Job No. 180213

June 29, 2023

Re: Response to CGS Comments
16975 Falcon Highway
El Paso County, Colorado

RMG – Rocky Mountain Group (RMG) prepared the *Soils and Geology Study* (RMG Job No. 180213, last dated June 28, 2023) for the proposed development comprising 7 single-family residential lots located approximately 2 miles east of the intersection of Curtis Road and Falcon Highway. The report was reportedly reviewed by personnel of the Colorado Geological Survey (CGS). The CGS comments (dated January 19, 2020) were reviewed on EDARP.

PRELIMINARY PLAN
SHEET 2 OF 3

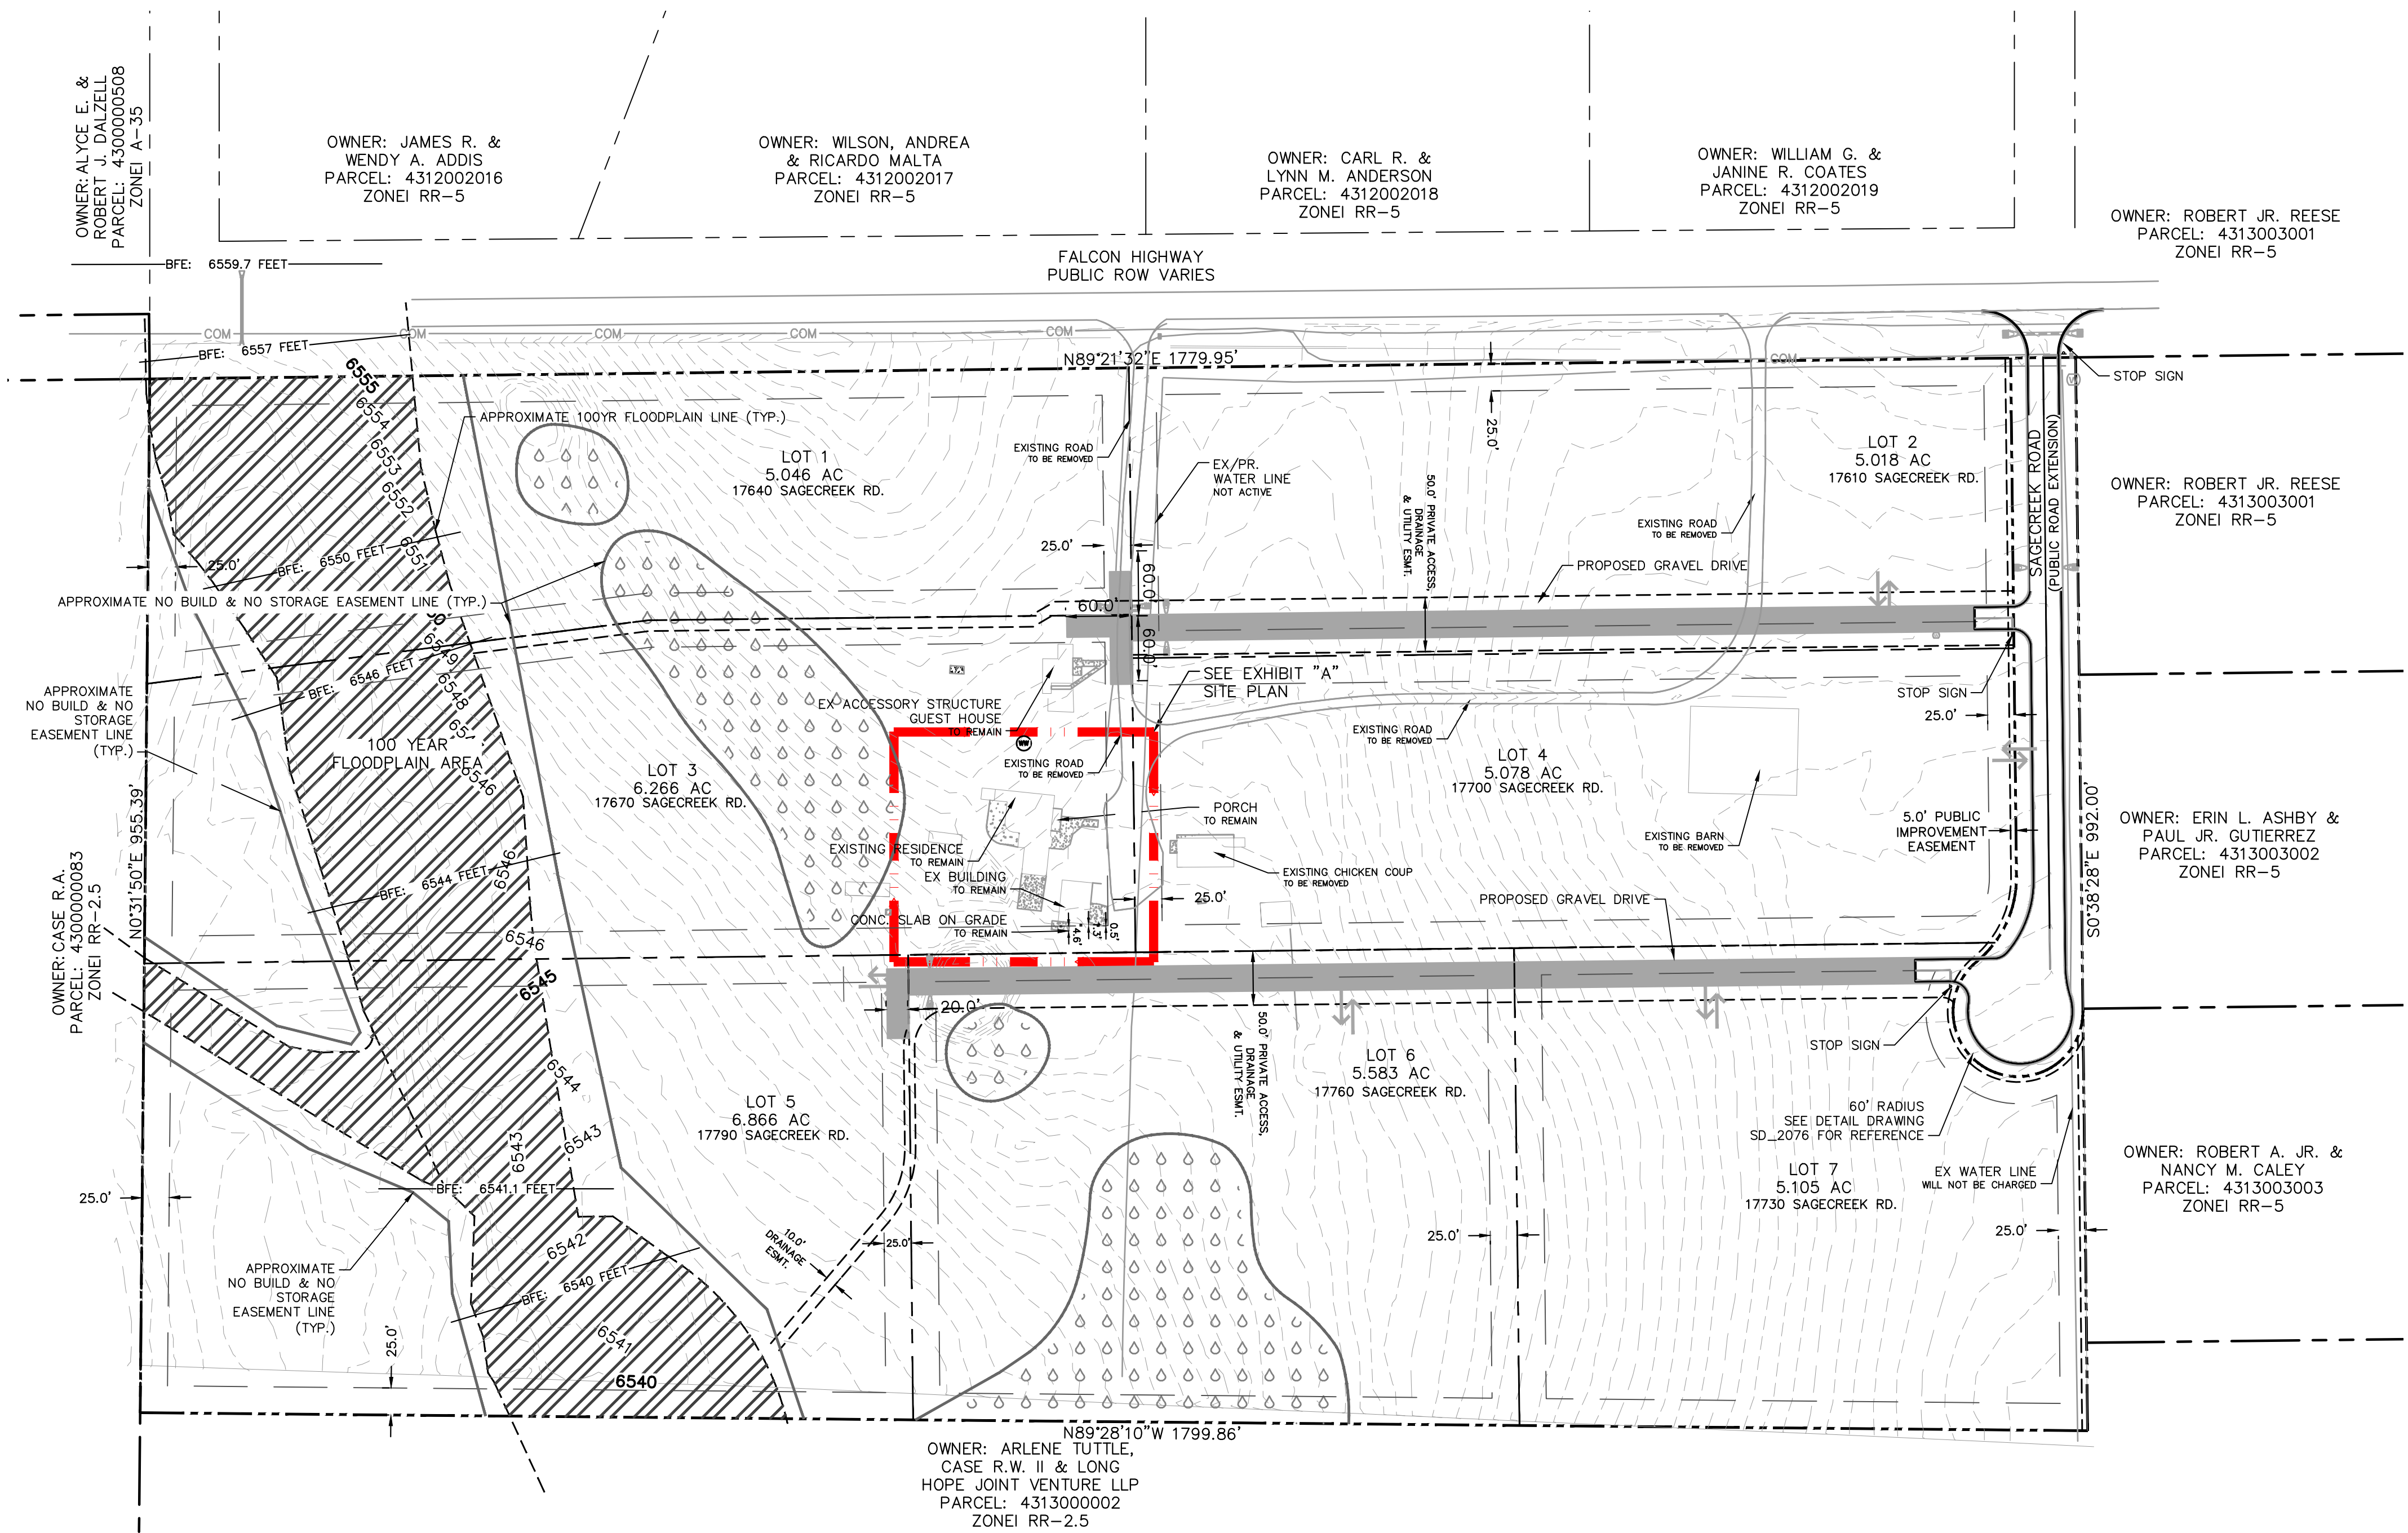
The Preliminary Plan (Kimley Horn, printed 12.21.21) includes a good note about potential geologic impacts on development. It would be prudent for the county to require an additional note on the plan that basements or crawlspaces are not allowed without data demonstrating adequate separation (approximately 3-5 feet) can be maintained from fluctuating groundwater levels. An unconfined aquifer was encountered in the subsurface investigation. RMG's report has gathered data at a specific time (in this case March, considered a seasonally low point in groundwater levels). This data is a "snapshot" of groundwater depth. No data is presented on the extent of groundwater fluctuation either seasonally or from year to year. Basements should not be allowed without groundwater monitoring throughout a 12-month period that clearly indicates adequate separation (approximately 3-5 feet) can be maintained from fluctuating groundwater levels. Impacts to the measured fluctuating groundwater levels from variations in yearly precipitation rates must be included in this analysis. Prior to approval of basement or other habitable below-grade construction site-specific investigations must provide data on the fluctuation of groundwater and how the variation of yearly precipitation rates may impact this fluctuation. All RMG's recommendations, and specifically ones concerning drains, should be strictly adhered to.

Proposed Lots 1, 5, and 6:

If basements are proposed on lots 1, 5, and/or 6, basement construction should be restricted on lots 1, 5, and 6 *except* where one of the following conditions apply:

Proposed Lots 2, 4, and 7:

Proposed Lot 3:

- A year-long groundwater monitoring study is undertaken, and the results indicate that groundwater is sufficiently deep to allow basement construction;
- The proposed construction will result in at least 15 feet of separation between the proposed ground surface and the groundwater elevation. Where groundwater encroaches shallower than 15 feet, the ground surface may be modified (raised) to increase the separation to meet these criteria.

If groundwater is encountered at the time of the site-specific subsurface soil investigations within 4 to 6 feet of the proposed basement slab elevation, an underslab drain should be considered in addition to the perimeter drain. It must be understood that subsurface drains are designed to intercept some types of subsurface moisture and not others. Therefore, the drain(s) could operate properly and not mitigate all moisture problems relating to foundation performance or moisture intrusion into the basement area.

Based on the currently proposed building locations on lots 2, 4, and 7, it is our opinion that the proposed structures will have adequate separation from groundwater. We do not recommend that a basement feasibility study be required on lots 2, 4, or 7 provided that the

future structures are located in the eastern 1/2 of lots 2 and 4 or the eastern 2/3 of lot 7. If basement construction is proposed on the western portions of these three lots in the future, we recommend that those structures be subject to the same feasibility evaluations as recommended above for lots 1, 5, and 6.

New construction is not currently proposed on lot 3. If basement construction is proposed on lot 3 in the future, we recommend that those structures be subject to the same feasibility evaluations as recommended above for lots 1, 5, and 6.
